**Consultation Response from KC,
Highways Development Management**

2025/90314 Rose And Crown Inn, 132, Knowl Road, Golcar, Huddersfield, HD7 4AN

**Discharge of details reserved by conditions 3,4,5,6,7,8,9,10,11,12,13, 14,16,17,18,19,25,26 & 27
on previous permission 2024/90839 for erection of 7 Dwellings and associated infrastructure
following partial demolition of existing Public House (within a Conservation Area)**

Date Responded:19-3-2025.

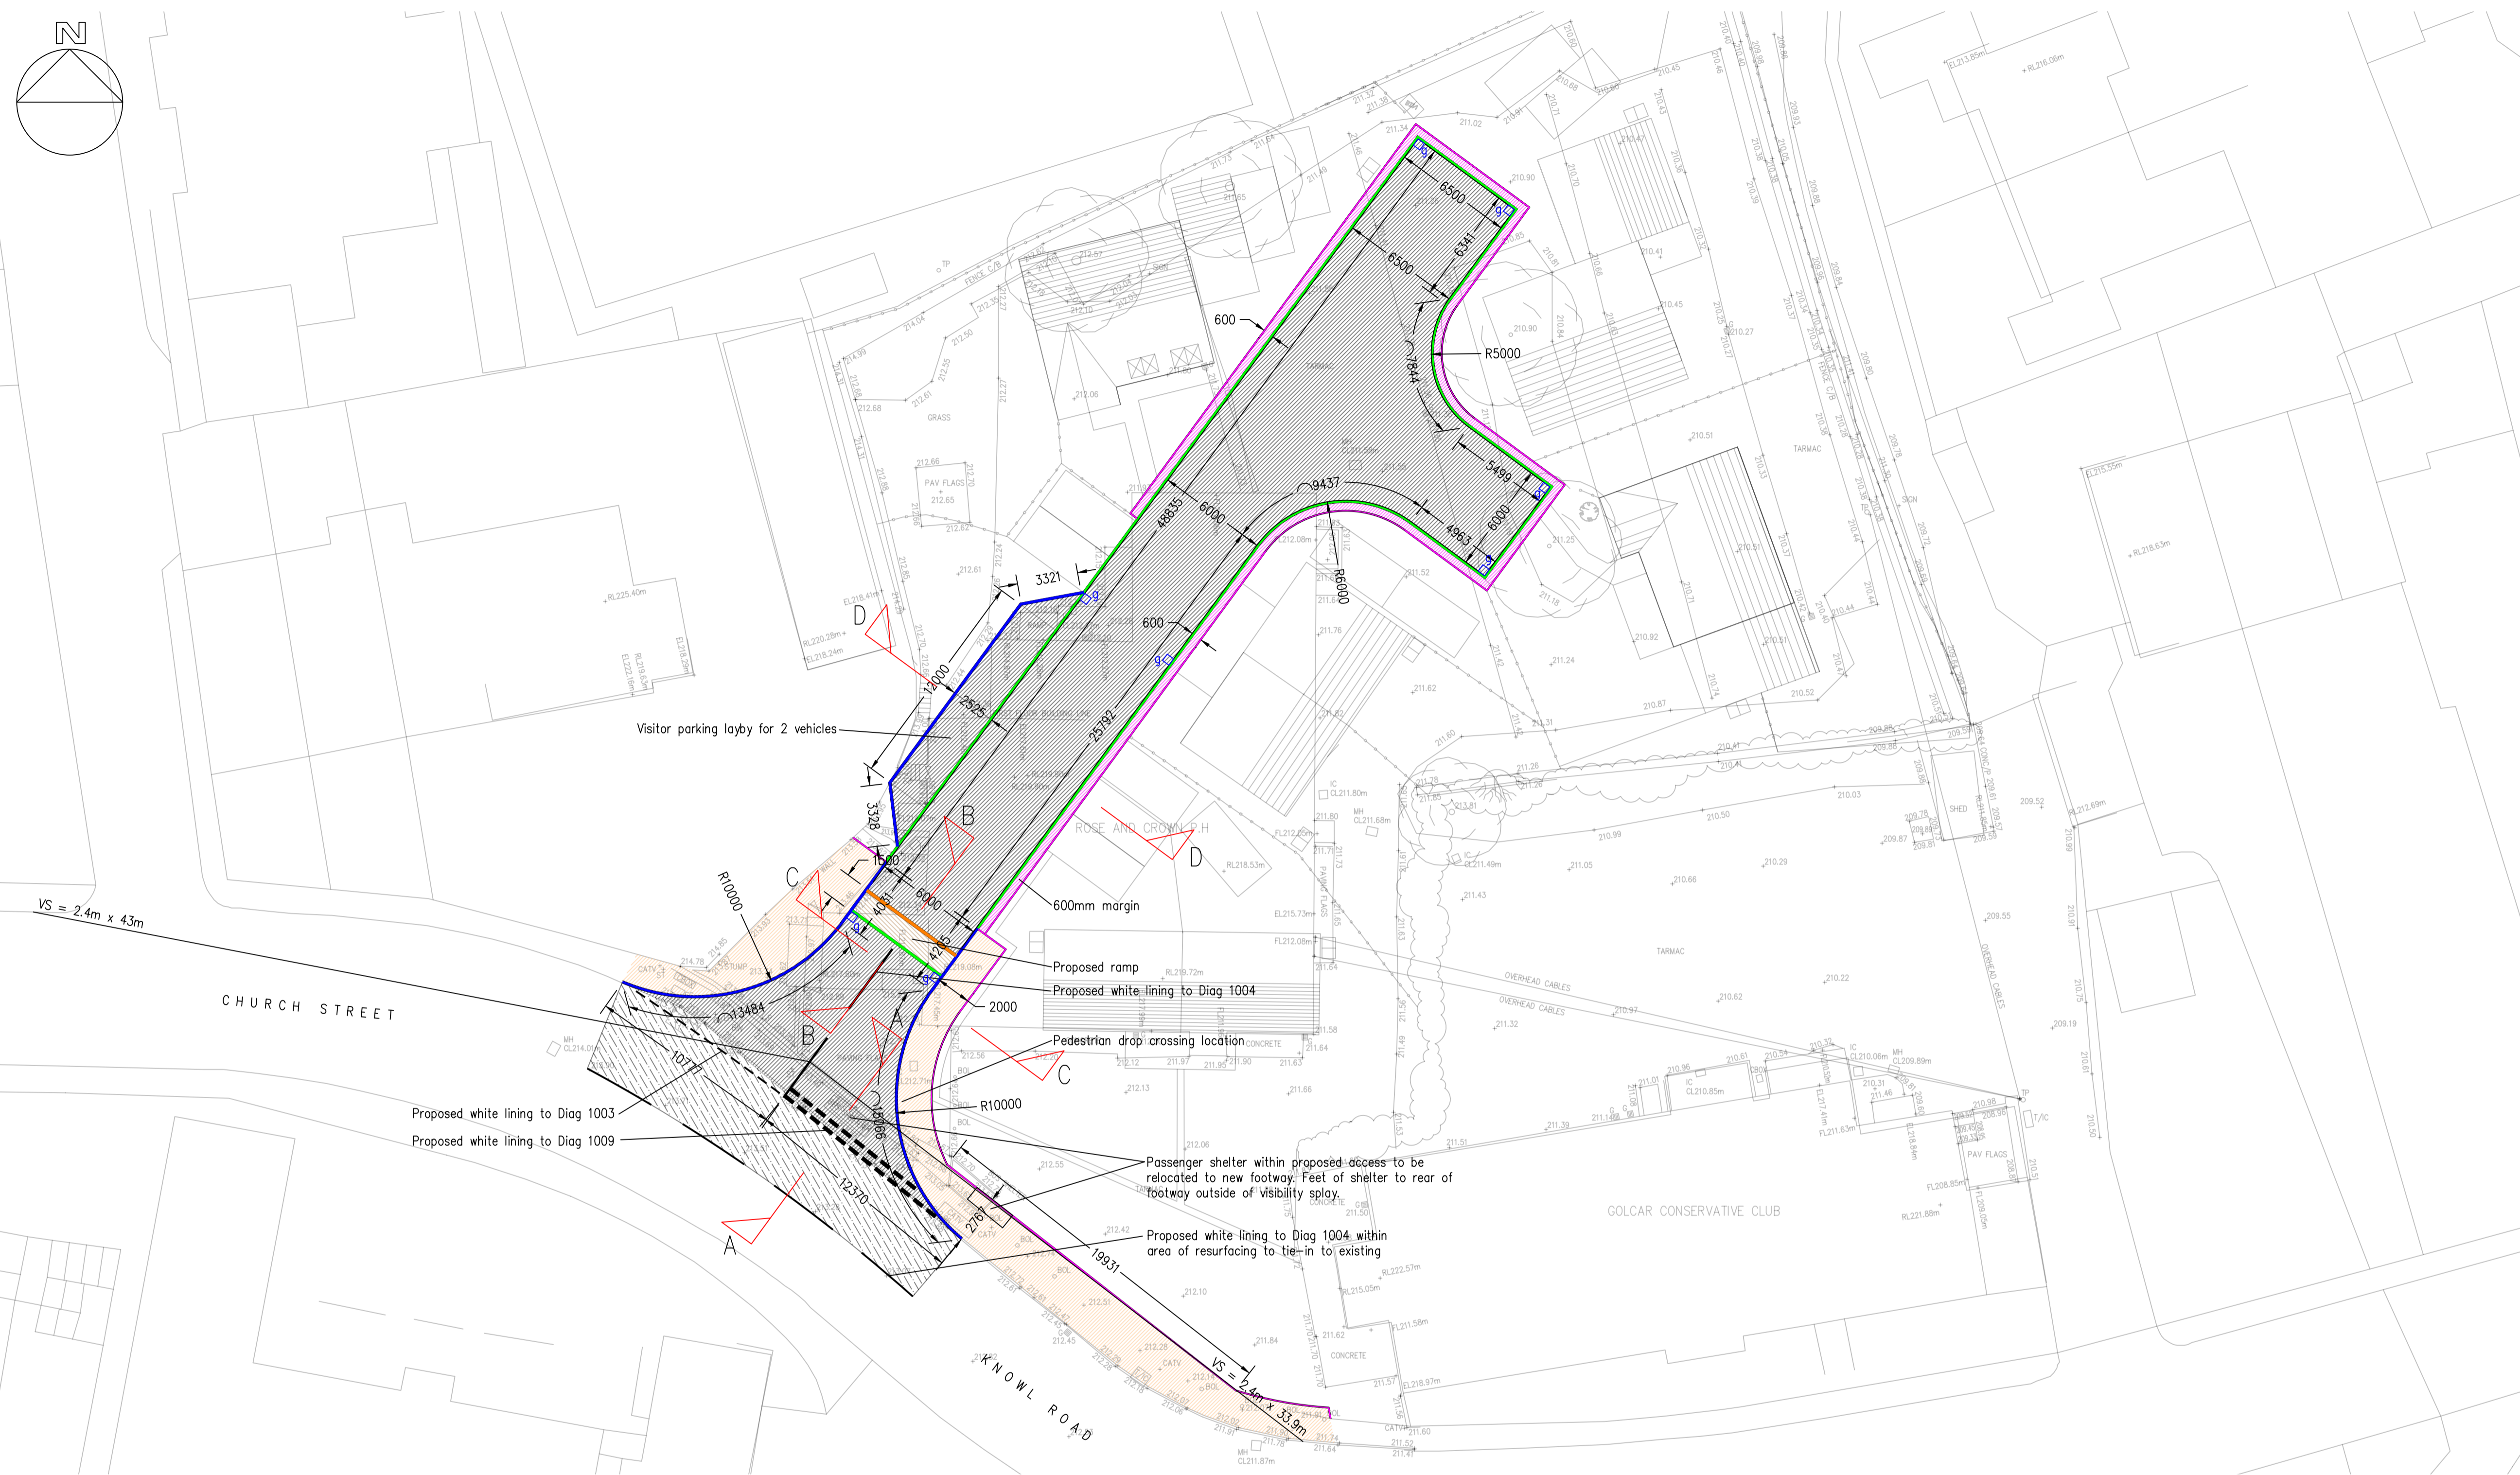
17. Development shall not commence until a detailed scheme for the provision of a minimum 2.0m wide footway to the full site frontage and the re-siting of the existing bus shelter to the rear of the visibility splay with associated signing and white lining has been submitted to and approved in writing by the Local Planning Authority. The scheme shall include construction specifications, white lining, signing, surface finishes together with an independent Safety Audits covering all aspects of the work. The approved scheme shall be completed before the occupation of the first dwelling on site.

No details are provided, and this condition should not therefore be discharged.
